January 18, 2019

Subject: Request for More Information
Vantage Bay Shoreline Substantial Development Permit (SD-18-00002)

January 2, 2019

RE: Comments for Vantage PUD Shoreline Substantial Development Permit

JOB NO.: 1396/001/014
 DWG. NAME: ST-01
 DESIGNED BY:
 DRAWN BY: CJR
 CHECKED BY:
 DATE: 12/12/2018
 DATE OF PRINT:
ST-01
 1 OF 4 SHEETS

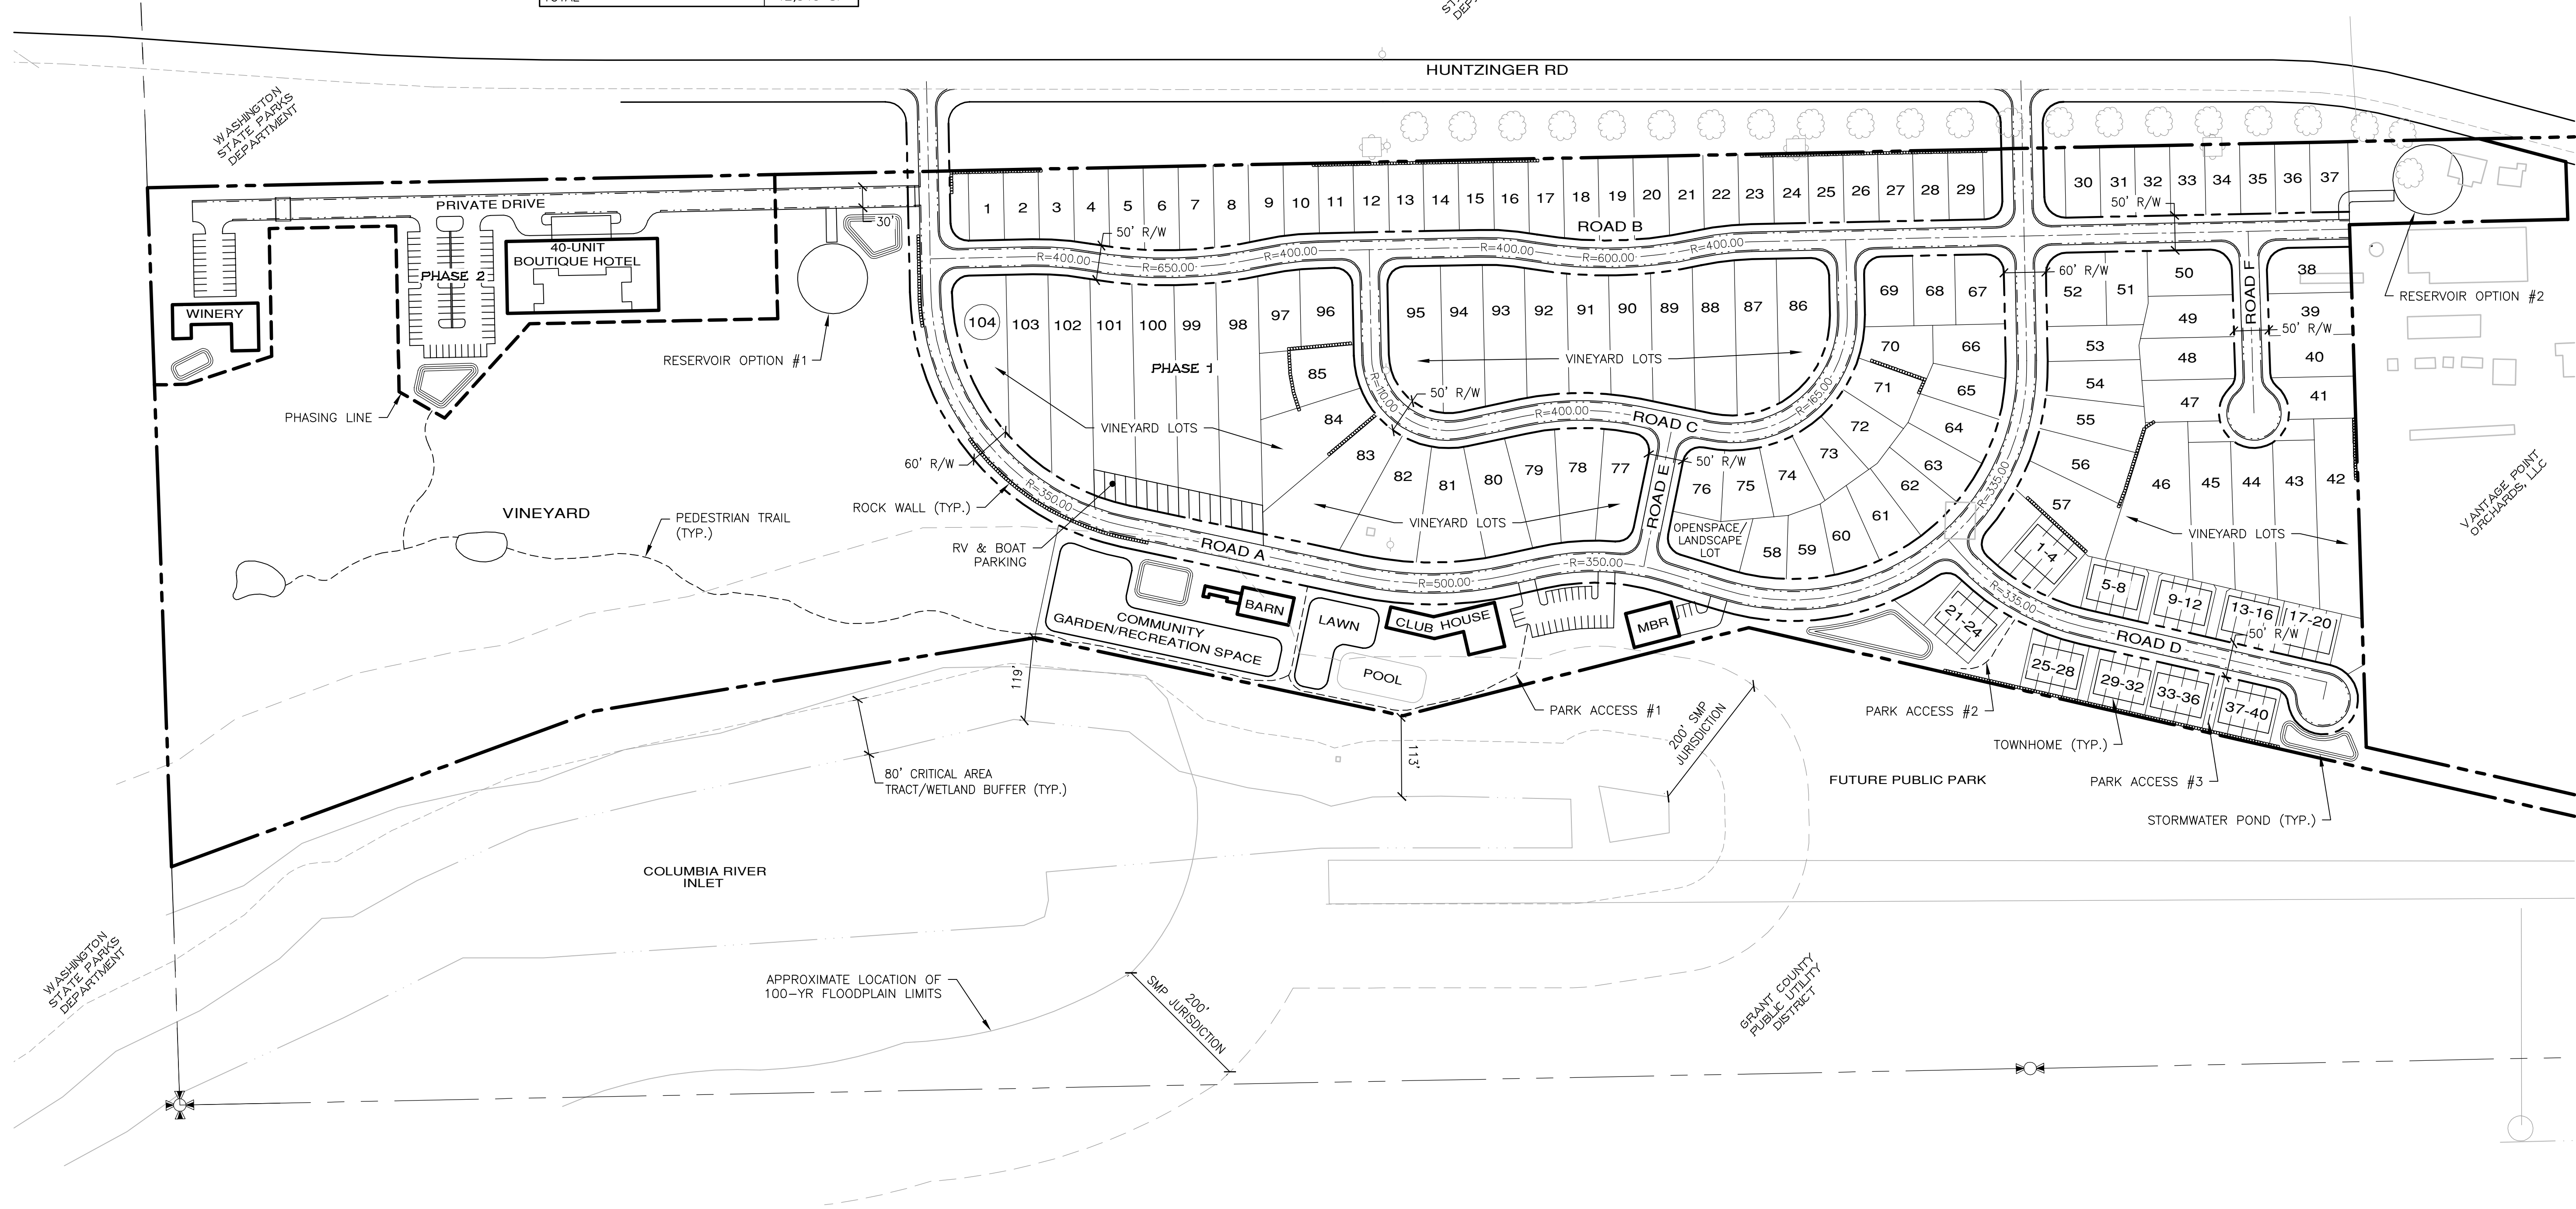
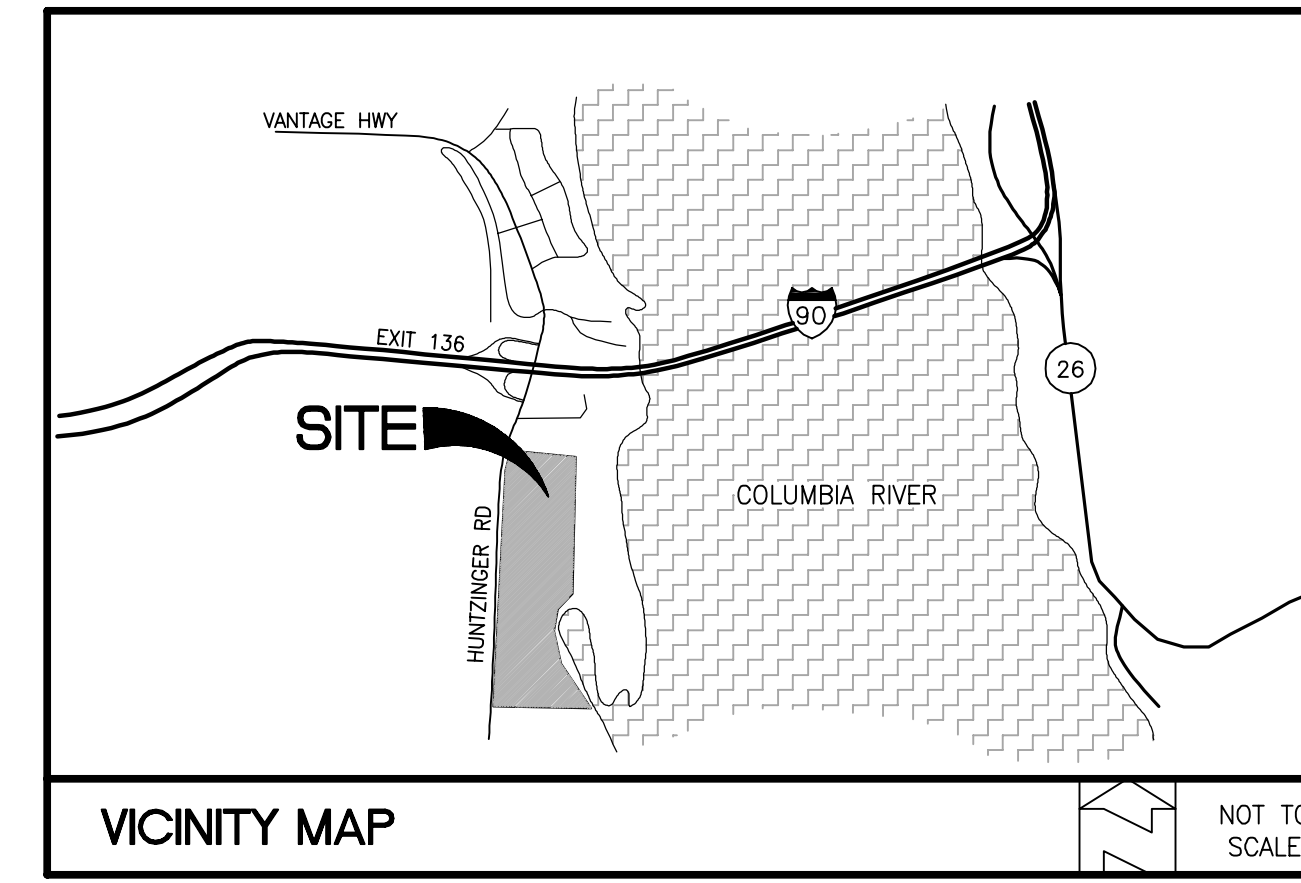
Plan sheets show an 80' wide buffer surrounding the potential category II or III wetland. Per the Approval Ordinance from 2006, a *minimum* 80' wide buffer is to be maintained from wetlands. According to Section 5.2(G), Table 5.2-1, Wetland Buffers for Wetlands in Shoreline Jurisdiction, wetland buffers for category III wetlands surrounded by high intensity use and development are to have a minimum of 150 feet wide buffer (200 feet for category II).

As the project is currently proposed, wetland buffer impacts are likely. With the information provided and the requirements of the County's SMP, the County should request a new wetland delineation and rating be conducted for the project site.

Per Kittitas County Code Title 17B.05.020F and 17B.050.020H "Wetlands shall be identified and delineated by a qualified wetlands professional in accordance with the most current approved federal wetland delineation manual and applicable regional supplements." As noted in the comments provided by Department of Ecology, the existing updated wetland delineation is missing required elements. Please provide an updated delineation.
